Development Facilitation Team (DFT) – Review Comments

Project No: PR-2022-006568 Date: 2/26/2025 Agenda Item: #7 Zone Atlas Page: C-20

Request: Final Plat of 2 Lots into 8 Lots with Right-of-Way Dedication.

Project Name: VALENTINO ESTATES

DRAWING NO:
LS-101

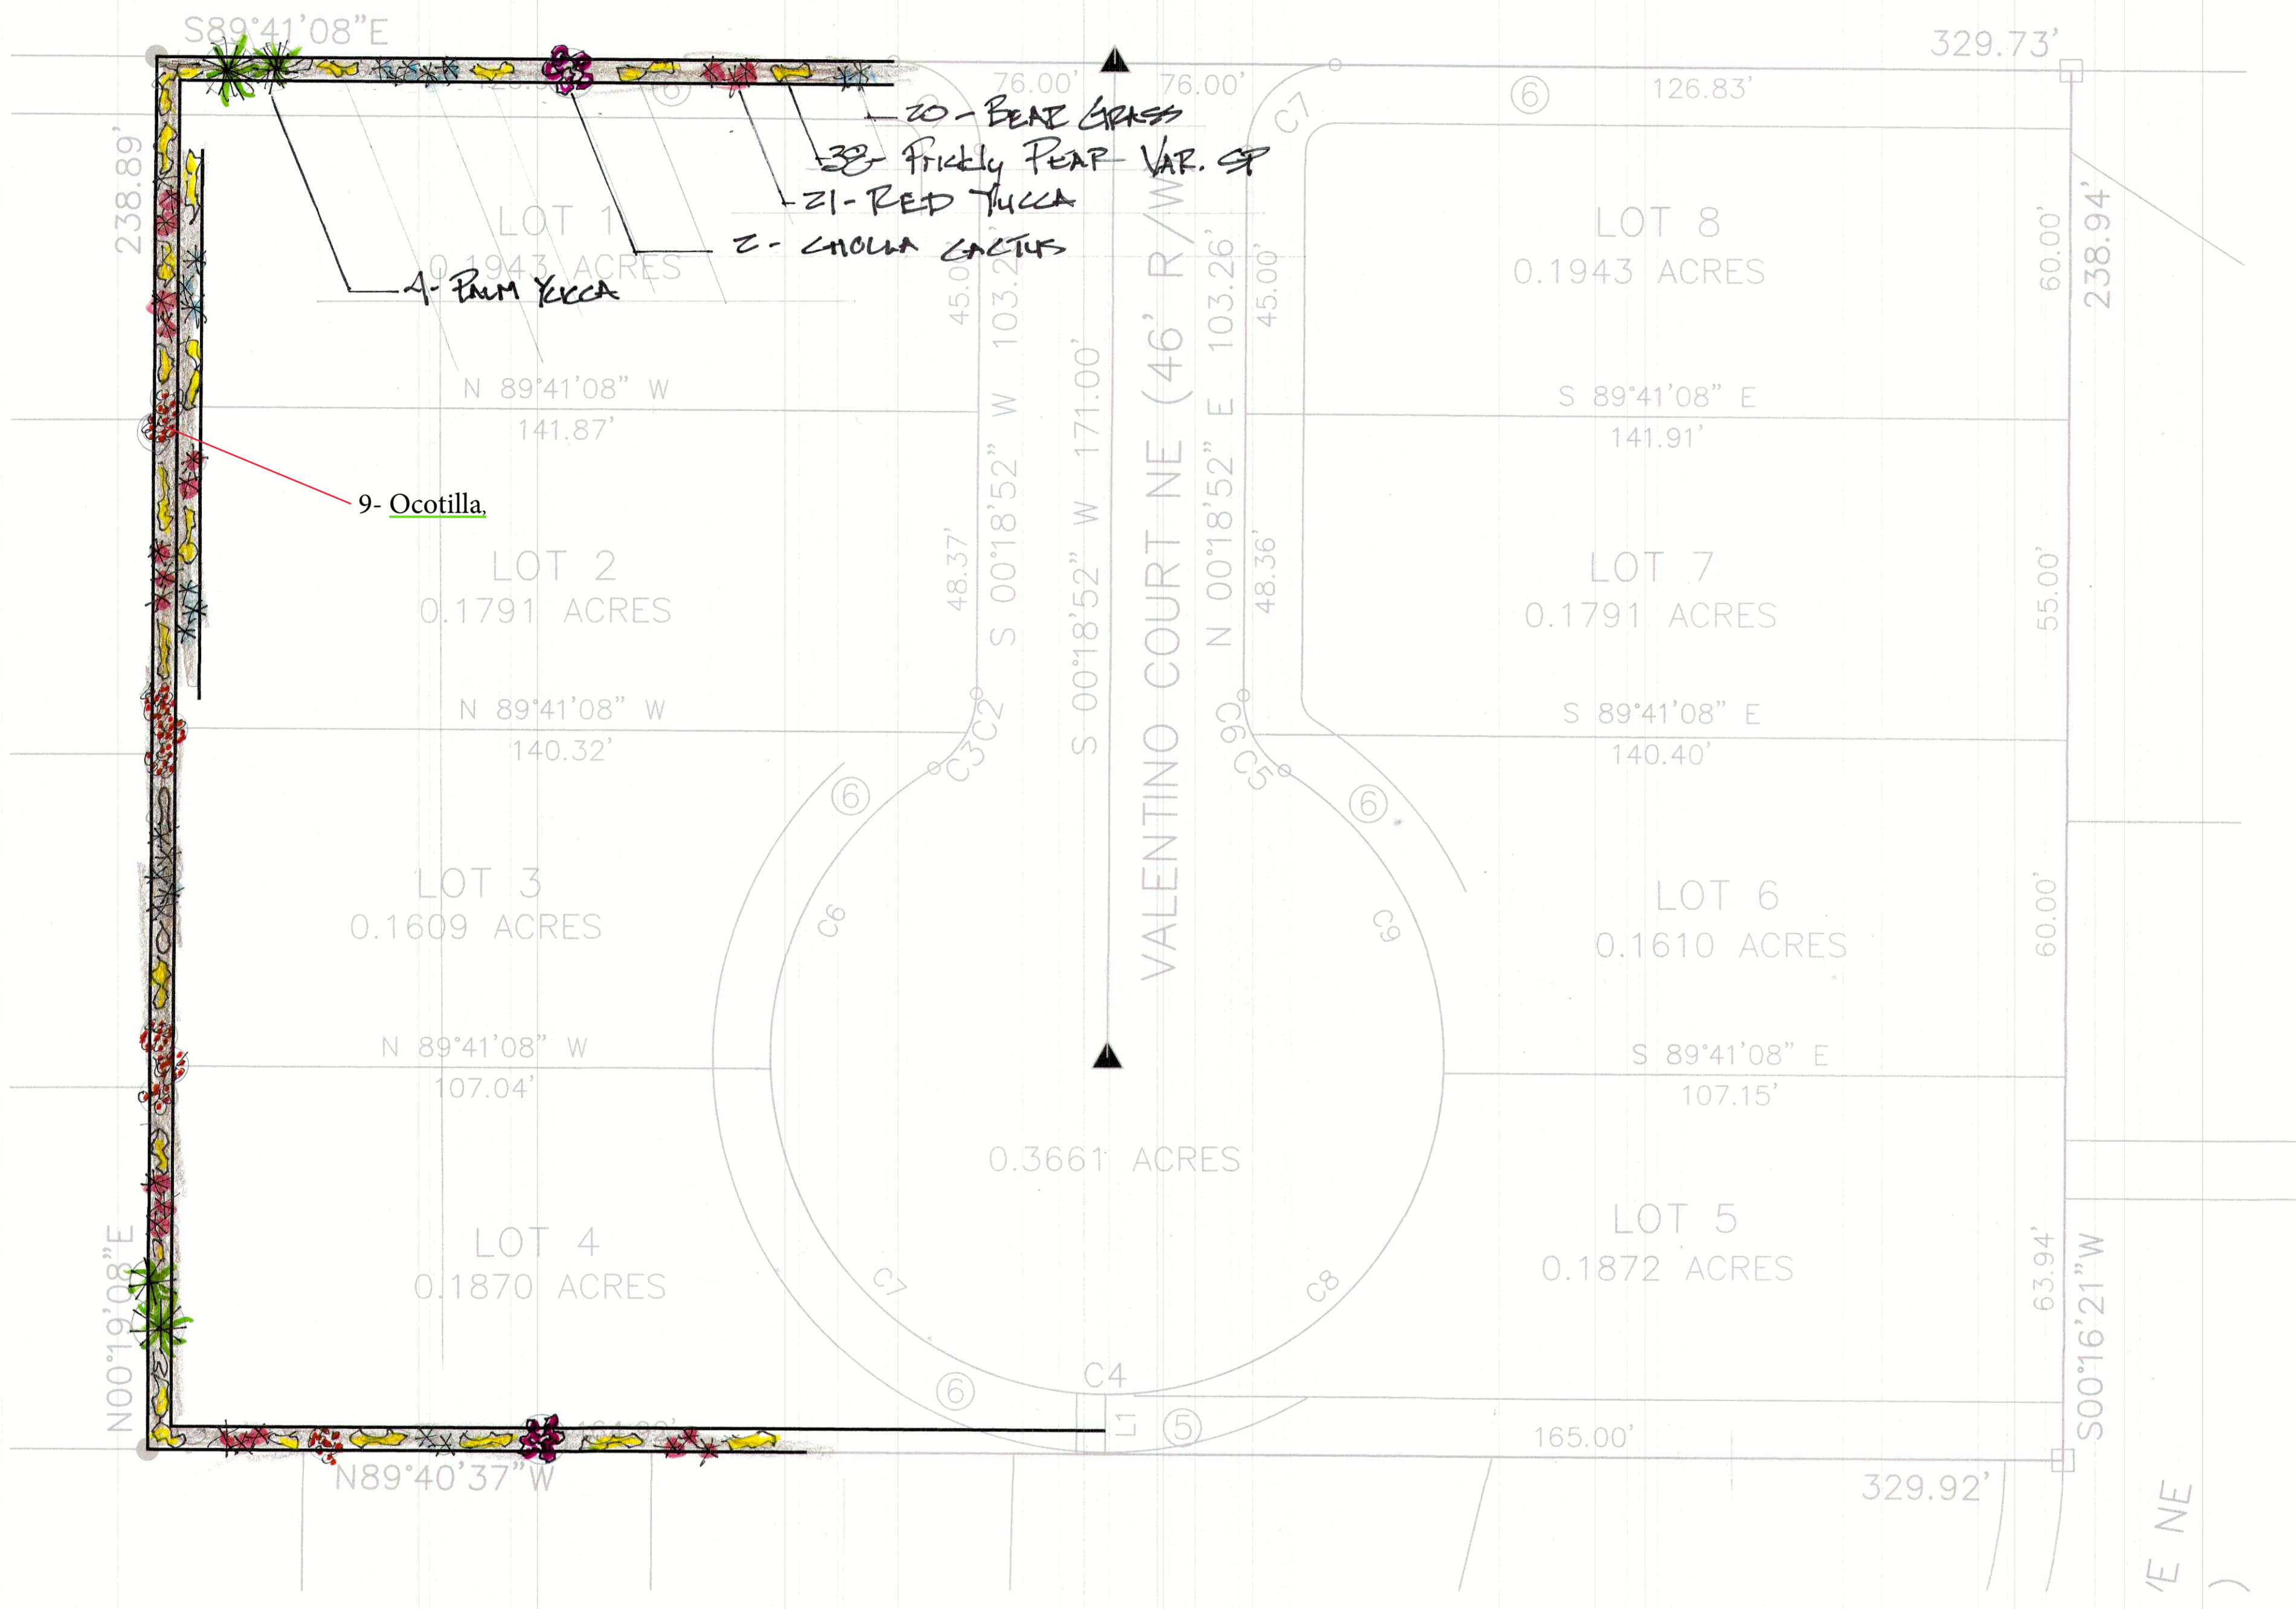
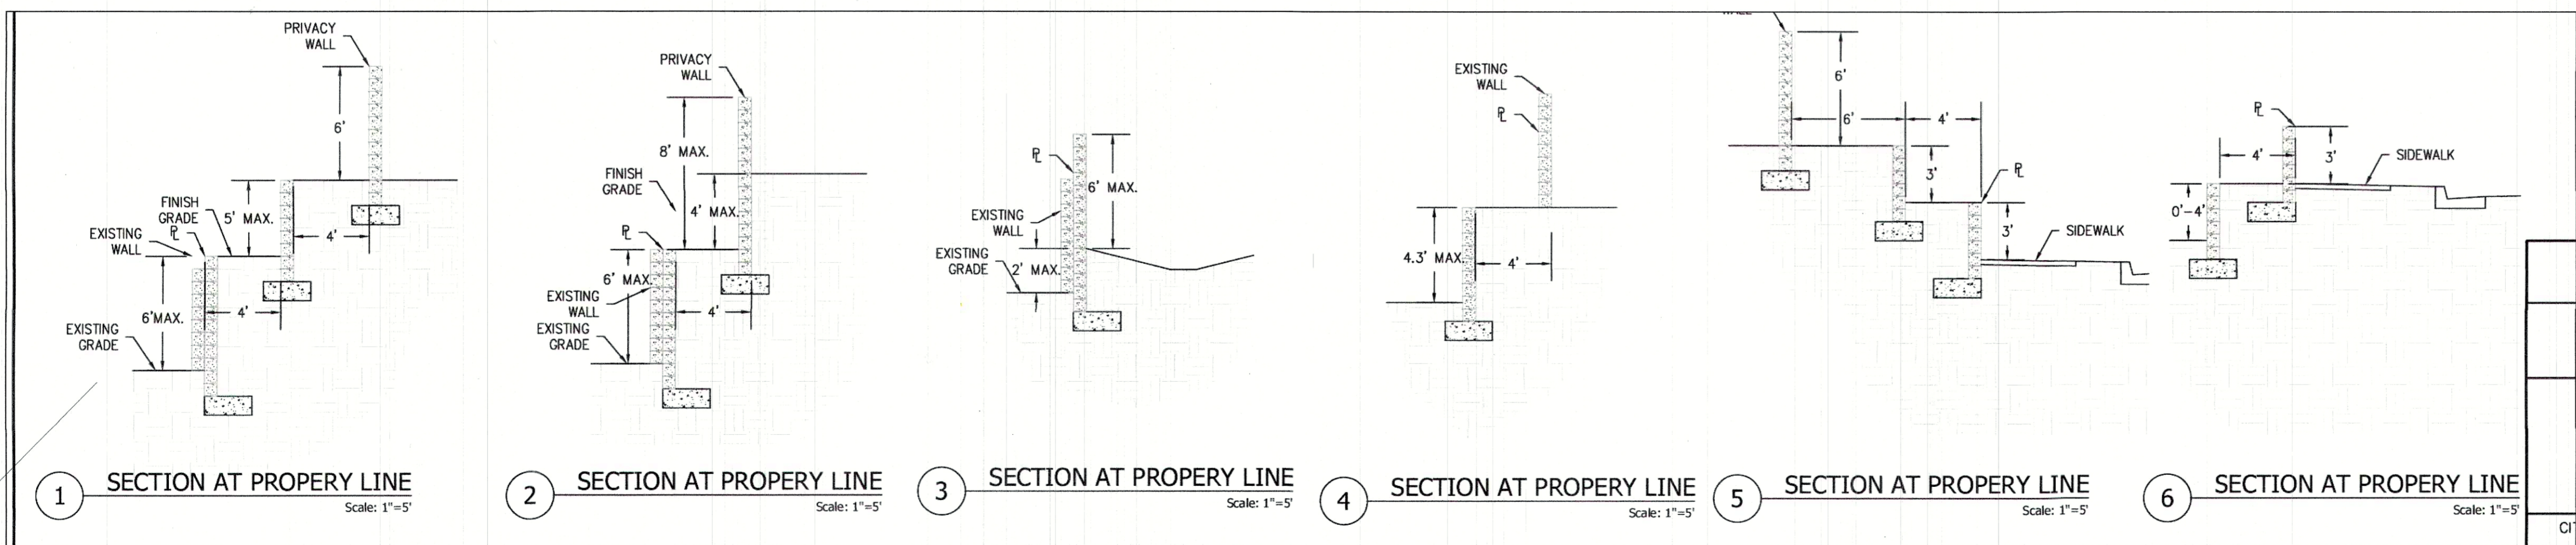
- Per Condition "a" of the Preliminary Plat for PR-2022-006568 / SD-2023-00147, dripline irrigation is required for the landscape terraces. Hand-watering is acceptable for 24 months prior to the issuance of a Building Permit. Staff recommends this condition be revised in the Final Plat approval to the following language:

The landscaping as depicted on the landscape exhibit titled 'Wall Schematic' must be planted, with a dripline irrigation system installed/provided within the Landscape Terraces depicted on the landscape exhibit, prior to the issuance of the first Building Permit for a residential dwelling on the subject property of this Plat.

A dripline irrigation system is required to operate for a minimum of 24 months after the planting of landscaping in the Landscape Terraces as depicted on the landscape exhibit, after which hand-watering is acceptable.

- Per Condition “c” of the Preliminary Plat for PR-2022-006568 / SD-2023-00147, plant species are to generally follow the City of Albuquerque Plant List but can be changed at Final Plat with concurrence between the developer and the neighbors. If this is necessary, a revised Landscape Exhibit will need to be submitted.
